# Rezoning Transportation Analysis

Petition Number: 2020-039

General Location Identifier: Tax ID 12709221

Date	Description
04-22-20	First Review
05-20-2020	Second Review
06-25-2020	Third Review (TV)

**REZONING SITE PLAN**  
PETITION # RZP-2020-039

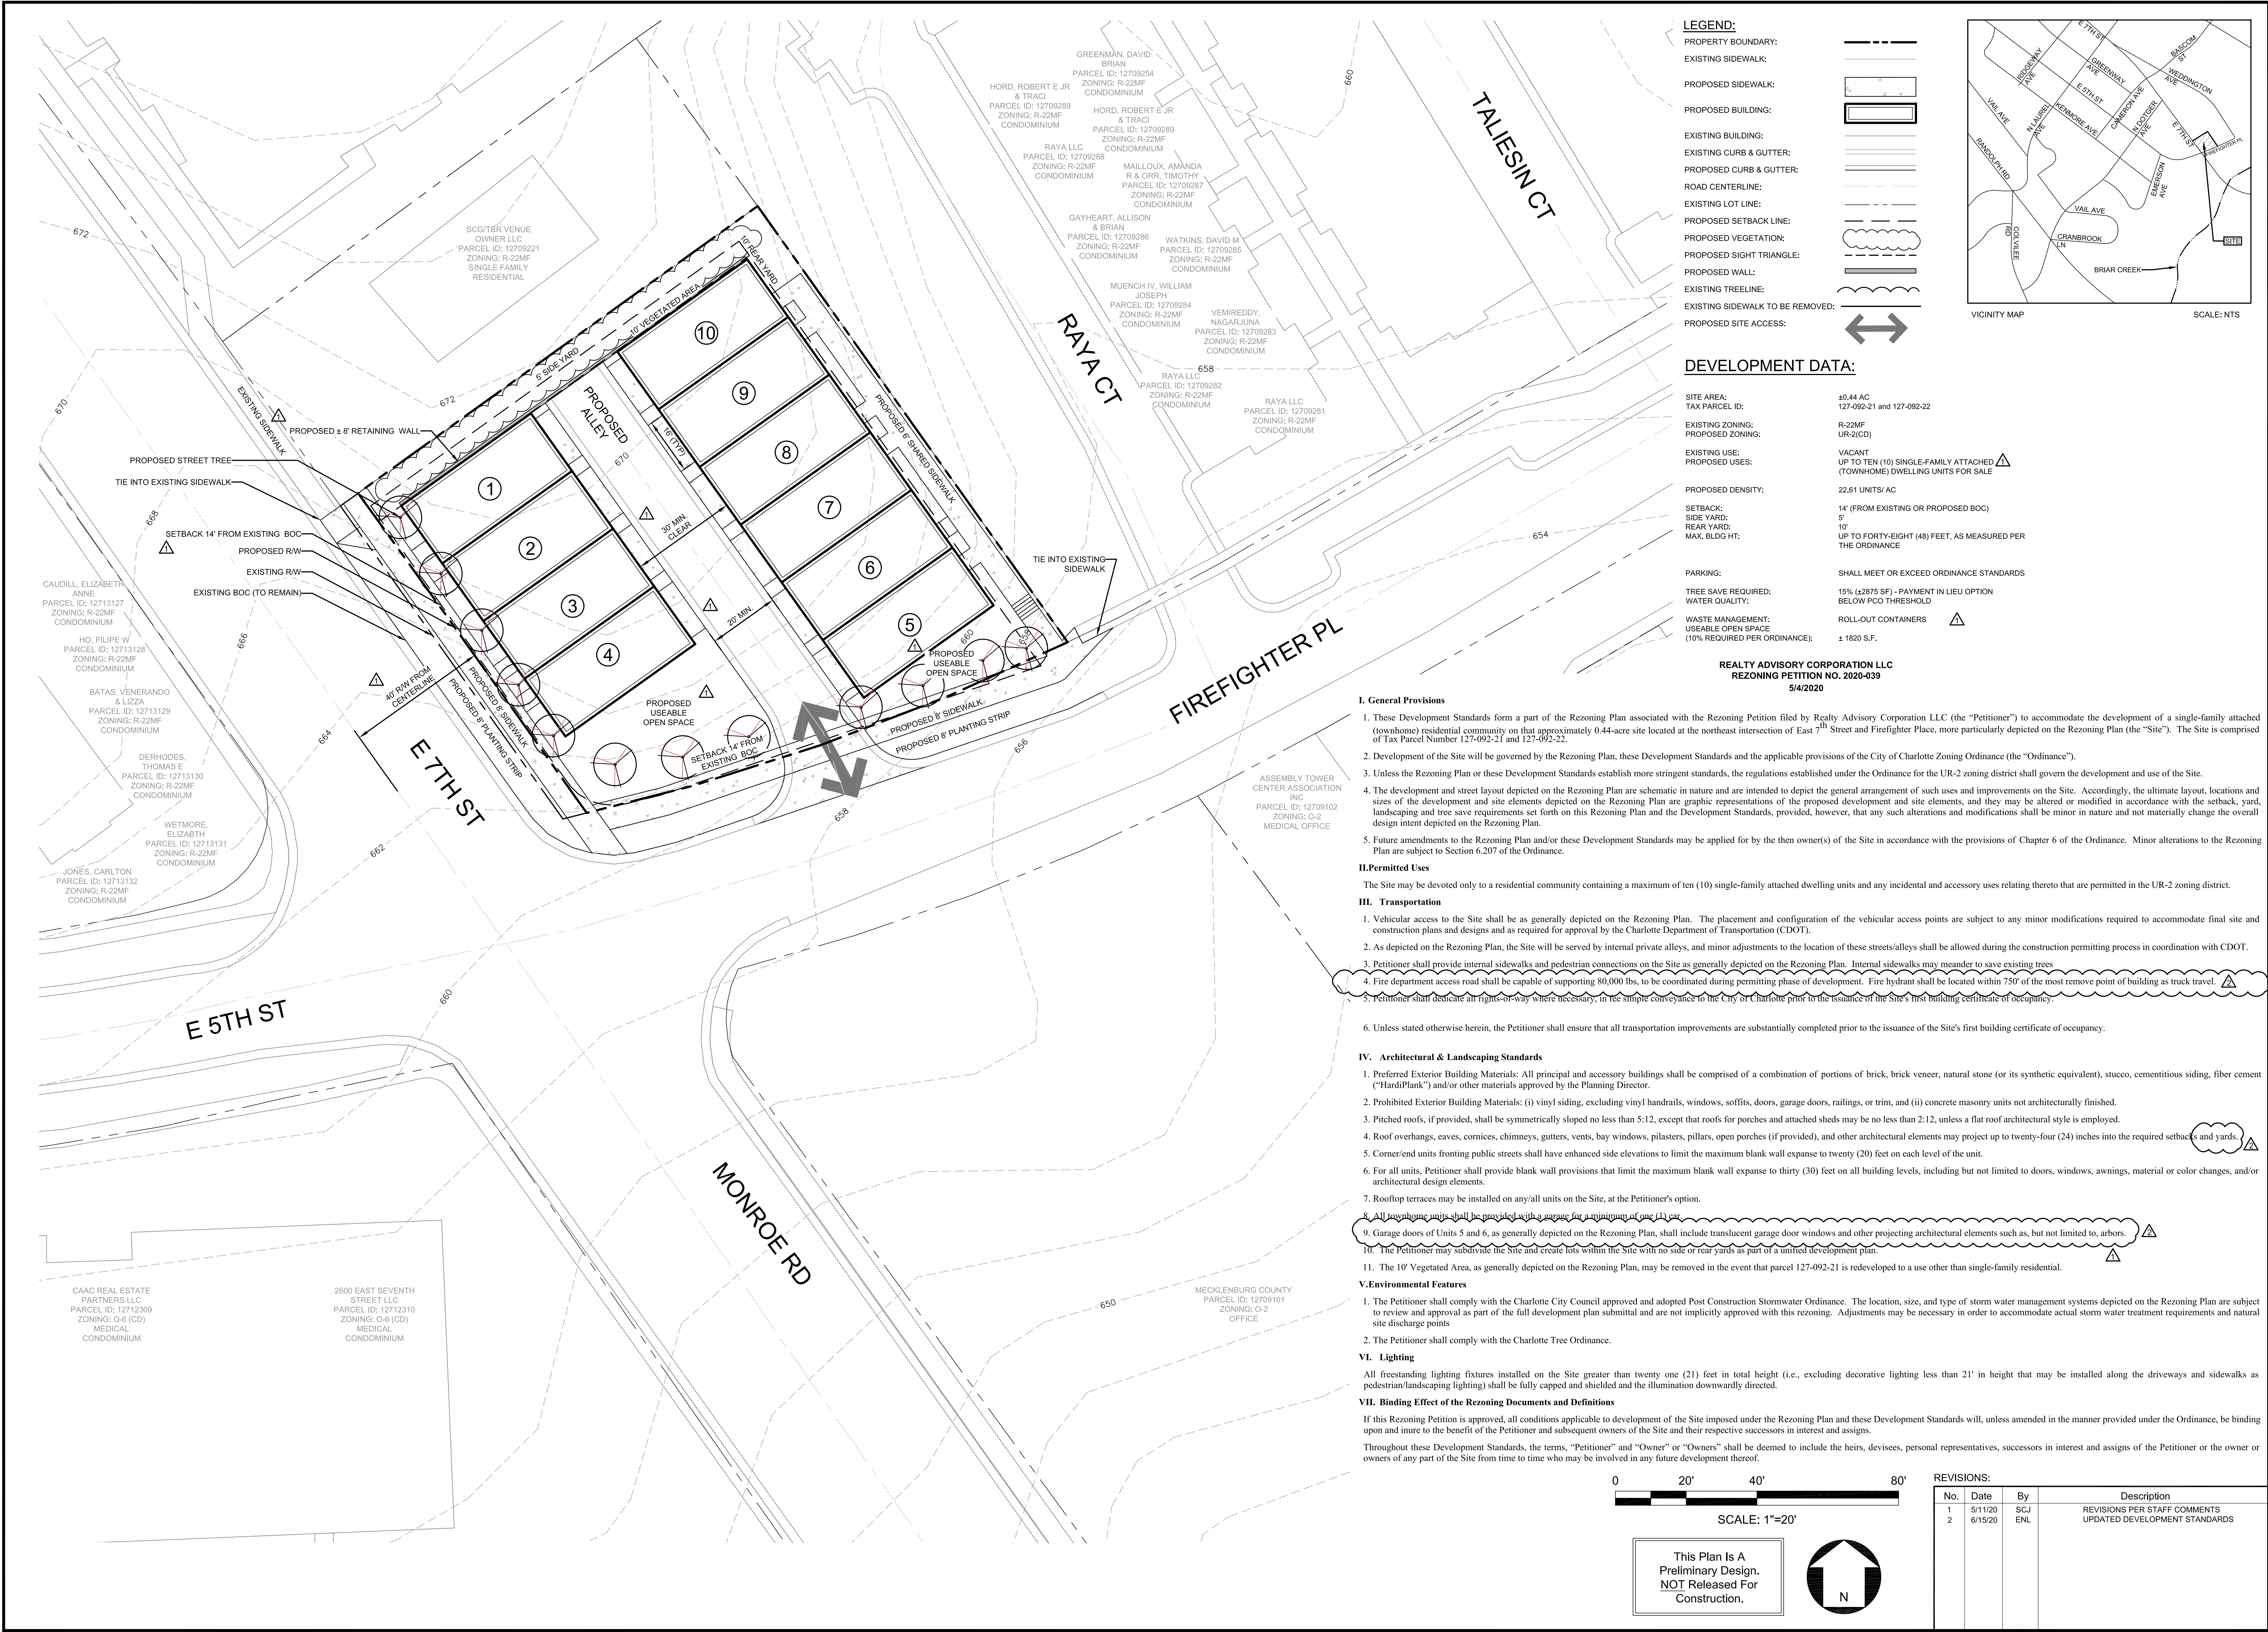
4. The petitioner should revise the site plan and conditional note(s) to commit to construct dual ramps at the corner of E 7<sup>th</sup> Street and E. 5<sup>th</sup> Street to meet the City's Charlotte WALKS Policy and PROWAG. In addition, the developer should commit to provide accessible push buttons for its corner. The site plan should label and dimension both items from the back of curb and gutter and road centerline.

5. We request for the petitioner should revise the site plan and conditional note(s) to commit to construct dual ramps at the corner of Monroe Road and E. 5<sup>th</sup> Street to meet City's Charlotte WAKS Policy and PROWAG. The site plan should label and dimension both items from the back of curb and gutter and road centerline.

6. The petitioner should revise the site plan to add a note specifying dedication and fee simple conveyance of all rights of way to the City before the site's first building certificate of occupancy is issued. CDOT requests right of way set at 2' behind back of sidewalk where feasible.
7. The petitioner should revise the site plan to add a note specifying all transportation improvements will be approved and constructed before the site's first building certificate of occupancy is issued. The petitioner may phase transportation improvements if said improvements and phasing are explicitly described in site plan notes.
8. ~~Resolved~~ ~~Sample format for comment that is resolved~~
